Application No: FG/34/21/HH
Site Address: 50 Ocean Drive Ferring BN12 5QP
Description of works: 1st floor side extensions, two storey front extension, side and rear extensions, installation of balcony to rear and 2 x front dormers including demolition of existing garage.

Thank you for your internet representation made on 28th March 2021 which has been recorded as an objection with the comments as follows:

REAR (w)

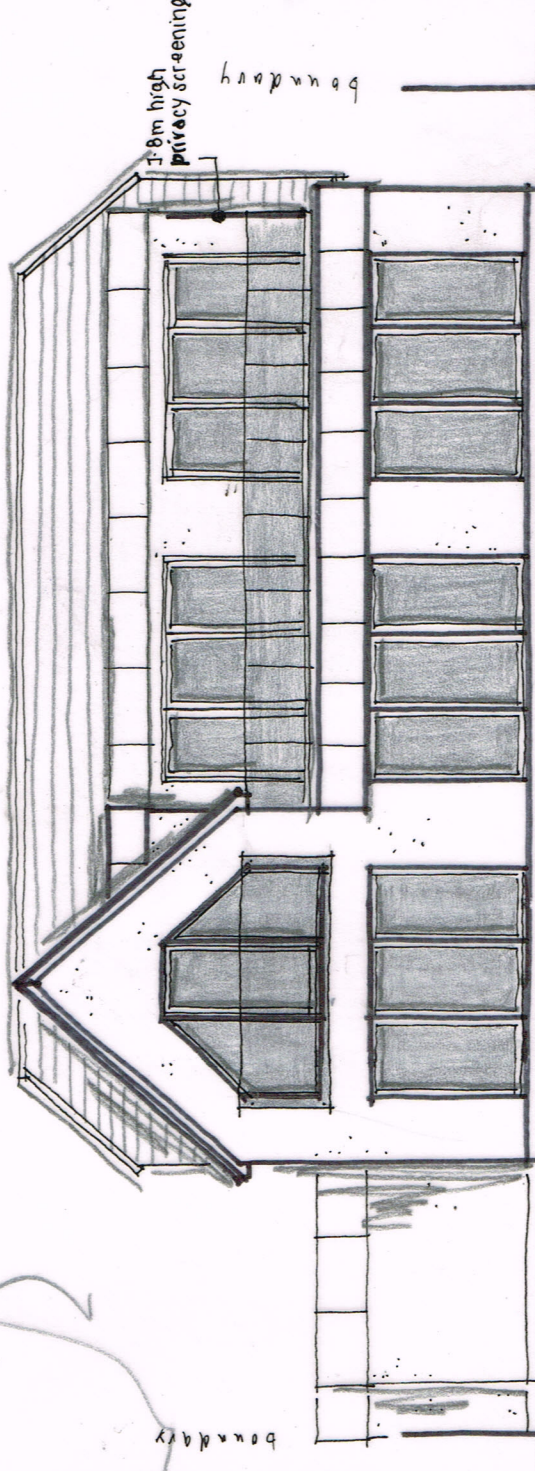
My objection to the development is that it represents a dramatic rise in height and scale of the overall building which will dominate the surrounding buildings which I feel is unreasonable. Most importantly the proposed large balcony and windows on the first floor of the west elevation will mean the householder will have extensive views overlooking the neighbouring gardens including mine which I feel will be obtrusive and an invasion of our privacy.
